Ref: SSD-79276958

RE: SUBMISSION TO SSD-79276958 FOR RESIDENTIAL FLAT BUILDING WITH INFILL AFFORDABLE HOUSING

ATTACHMENT 1

Figure 2: Building Height Plane 3D Diagram  
Source: DKO

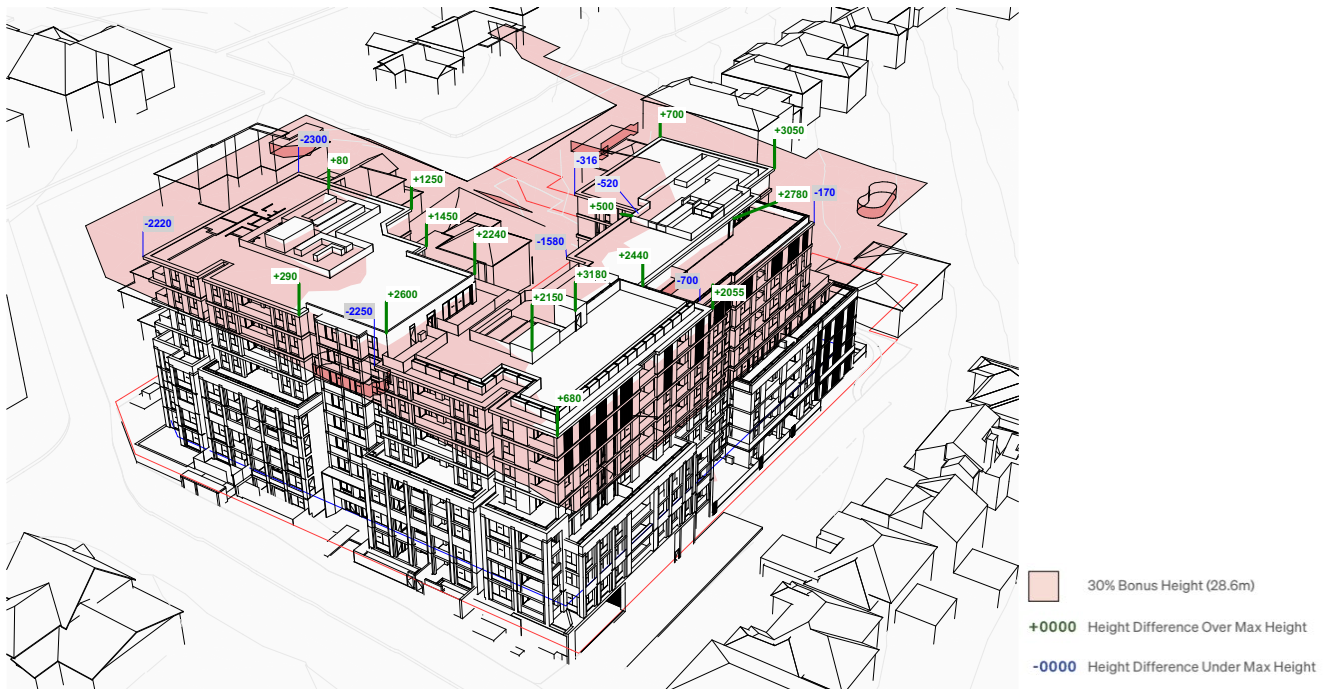
A Clause 4.6 written request forms part of the application, indicating a maximum building height of 33.07m which exceeds the maximum building height by 4.47m (15.60%). The subject application's 'Height Plane' (drawing no. DA500) drawing is provided in **Figure 3** below:

Based on **Figure 2**, it is observed that the largest non-compliance in building height occurs at the roof parapet of the proposal (+4470). However, the maximum building height of the proposal cannot be correctly calculated due to insufficient detail on the architectural plans provided. It is acknowledged that the 'SITE PLAN' (drawing no. DA102) contains proposed roof level RLs. However, when attempting to assess the maximum building height contravention (+4470) by overlaying the 'SITE PLAN' with the exhibited Survey Plan, EGLs directly below this point are not annotated. This can be observed in **Figure 4** below:

The extent of variation is not considered to be “...*limited to a part of the uppermost levels*”. Rather, it is considered that significant portions of the roof exceed the maximum building height. This is particularly evident on the proposal’s north-western roof, as depicted in **Figure 2** above, where only a minor portion of the roof complies with the maximum building height. The Clause 4.6 also states:

The breach in the maximum building height, as indicated on the architectural plans, is significant and amounts to large portions of the roof and the top floor of the development. For the Clause 4.6 variation request to be well founded, the variation from the development standard must be clearly articulated and justified. The consent authority must be satisfied that the Clause 4.6 variation is well founded before the granting of any development consent. With respect to Clause 4.6(3)(a) and (b) of the KLEP, it is Council's opinion that the variation request has not demonstrated that:
